OBSERVATION/SUBMISSION TO PLANNING APPLICATION

Case Reference: 324113

Re: Observation to the proposed development of open-cycle gas turbine (OCGT) and generator with ancillary equipment.

Location: Pollnagroagh and Rathmorrissy (Townlands), Athenry, Co. Galway

Purpose		PLANNING			
Title		SITE ACCESS SIGHTLINES			
Original Scale	Design/Drawn	Checked	Authorised		
SHOWN at A1	PS	ND	AJB		
Date	Date	Date	Date		
01.12.25	01.12.25	01.12.25	01.12.25		
Status	Drawing Number	Rev			
A2	PEK3-ATK-ZZ-01-DR-CE-901200	0

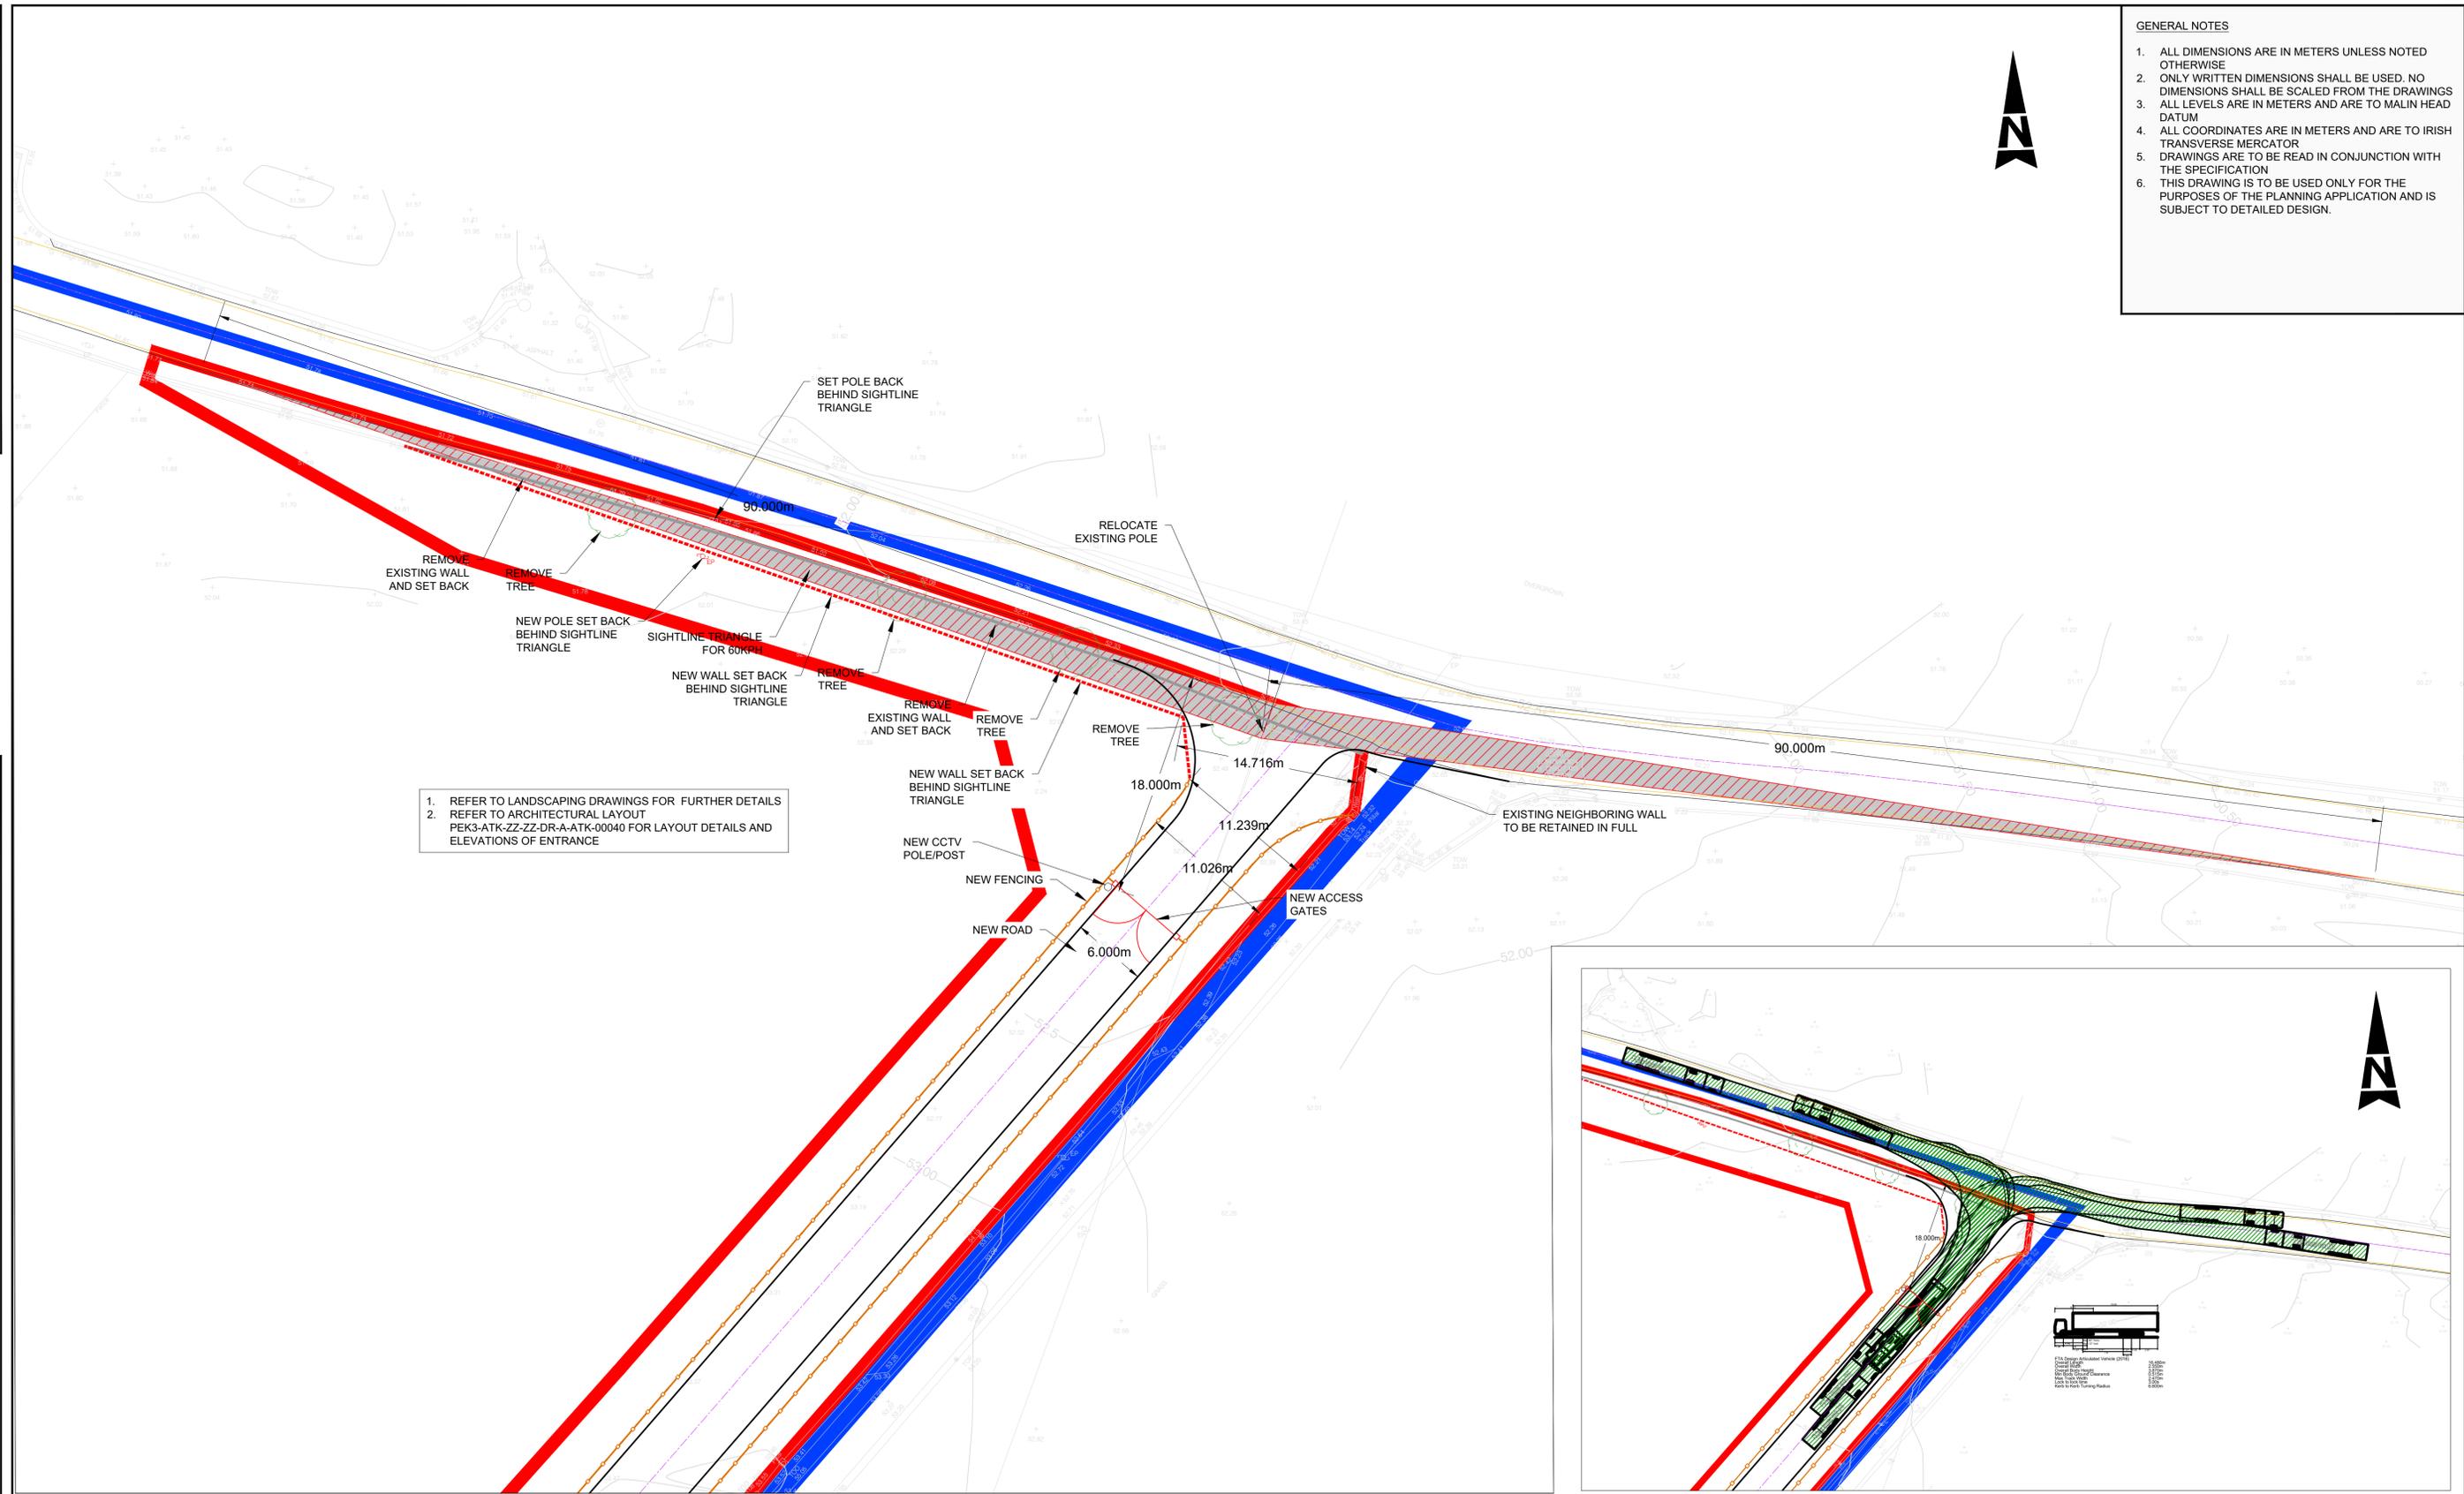
There are serious concerns about the proposed site entrance on the L3103, which is an exceptionally dangerous stretch of road where introducing an access point would create an unacceptable level of risk. The road is extremely narrow and cannot safely accommodate two heavy goods vehicles passing at the same time, there is no hard shoulder to allow for safe manoeuvring or recovery, and visibility is severely limited due to blind dips and sharp corners. These are significant existing hazards that already pose a real danger to road users, and the addition of a site entrance would further increase that risk.
